Re: State Significant Development Modification Application - SSD7155 MOD 3

I write in response to the public exhibition of the State Significant Development Modification Application No.3 (SSD7155 MOD 3) at 5-35 Yarrunga Street and 36-36A Kookaburra Road, Prestons (Lots 33-35 and Lot 43 DP 2359, Lot 20 DP 1173483, Lot A DP 408207 and Lot B DP 408207).

Please find below our submission in relation to the proposed modification application.

SITE PLAN
1: 1200 scale

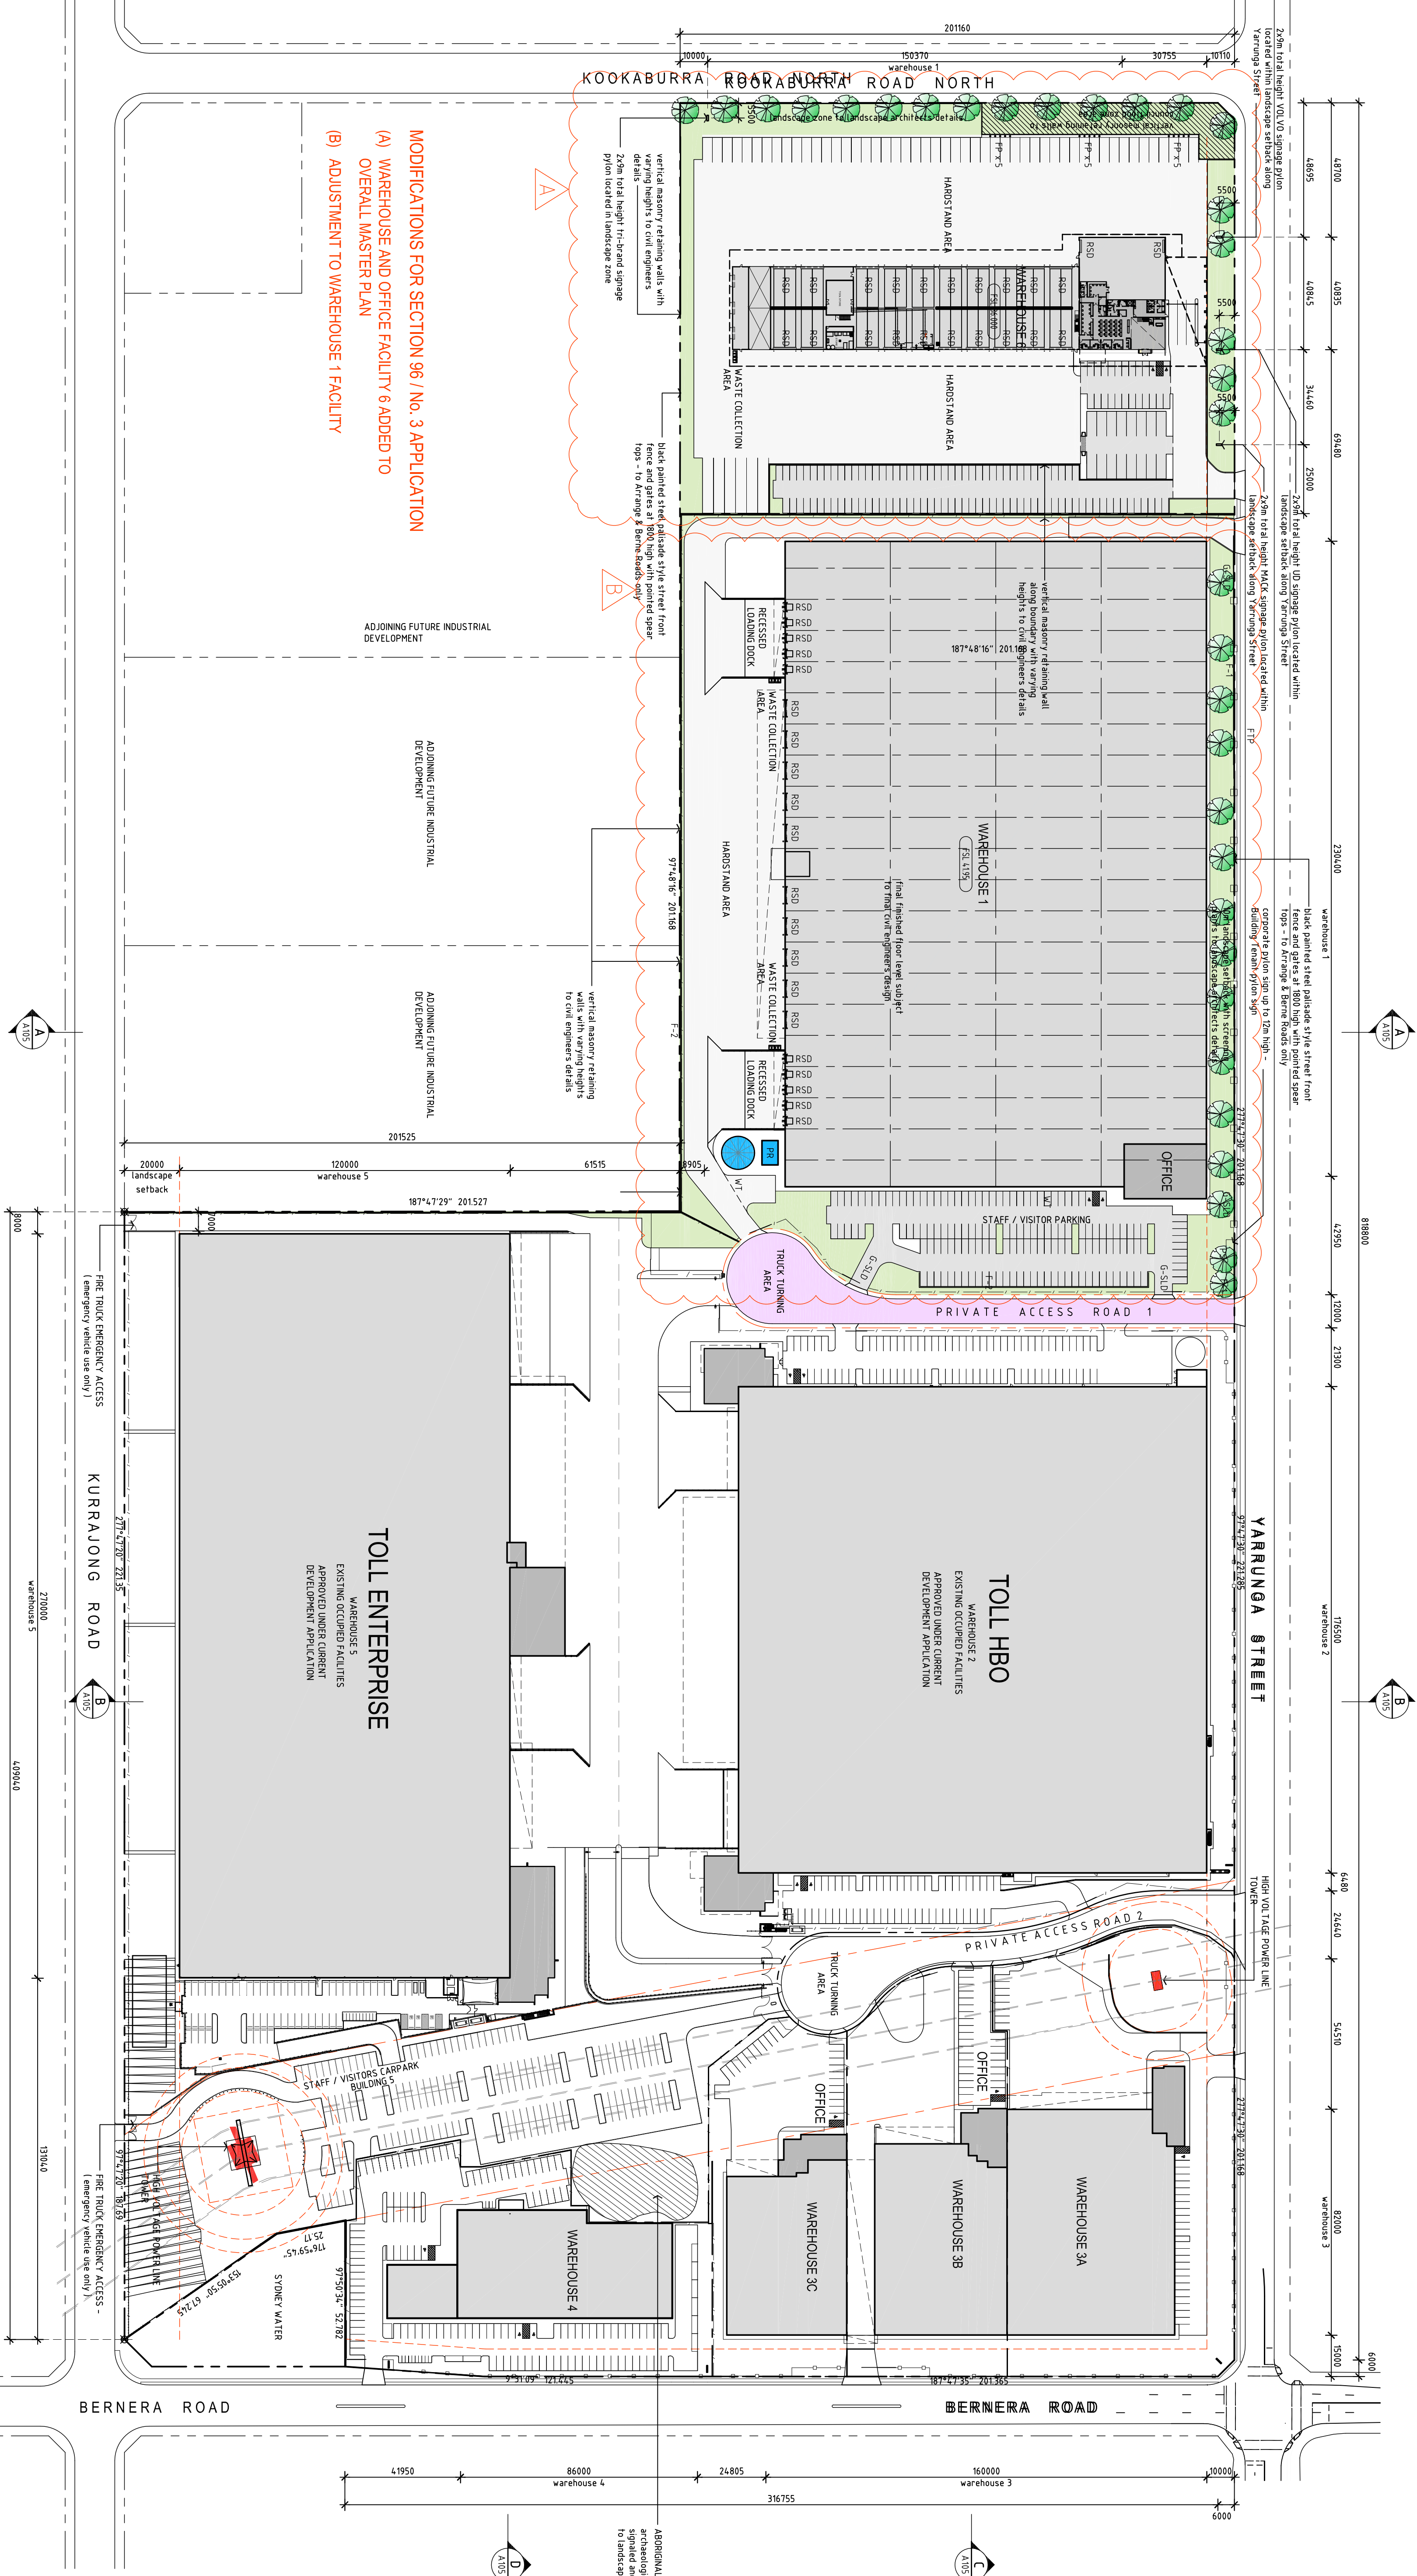
It is identified that fewer parking spaces are provided in the proposal compared to the car spaces required in accordance with Council's standard.

Proposed Development	Floor space (sqM)	Office space (sqM)	Car space-needed	Car space - proposed	Car parking Shortfall
Warehouse 1	35,370	1,200	506	152	354
Warehouse 6	4,670	1,800	114	124	-10
Total	40,040	3,000	620	276	344 (55% less)

Provision of less car parking spaces can be substantiated with the provision of other means of transportation such as adequate availability of public transport options and alternative transport arrangements which are not present within and near the subject site.

It is recommended the Department consider amendments to reduce the visual bulk of the warehouse along the Yarrunga Street frontage through the use of additional articulation and a suitable colour scheme.

Blank walls on any road frontage is discouraged. Provisions should be made to reduce the amount of retaining walls. Where blank walls are unavoidable, building elements or landscaping must be used to break up large expanses of wall.

The retaining walls on Yarrunga Street and Kookaburra Road need to be adequately landscaped to soften the visual impact. An anti-graffiti coating will need to be applied to the wall to a height of 2 metres.

Service areas including waste recycling areas and external storage areas are to be located away from the street frontage and screened from view.

The street facade on the corner of Yarrunga Street and Kookaburra Road must incorporate architectural corner features to add visual interest to the streetscape.

The carpark areas need to be appropriately landscaped. This will reduce the heat effect from the hard stand areas and reduce visual impacts.

It is recommended the subject site is connected with the cycle network adjacent to the site. Provisions of on-site cycle storage is recommended to encourage active transportation for employees.
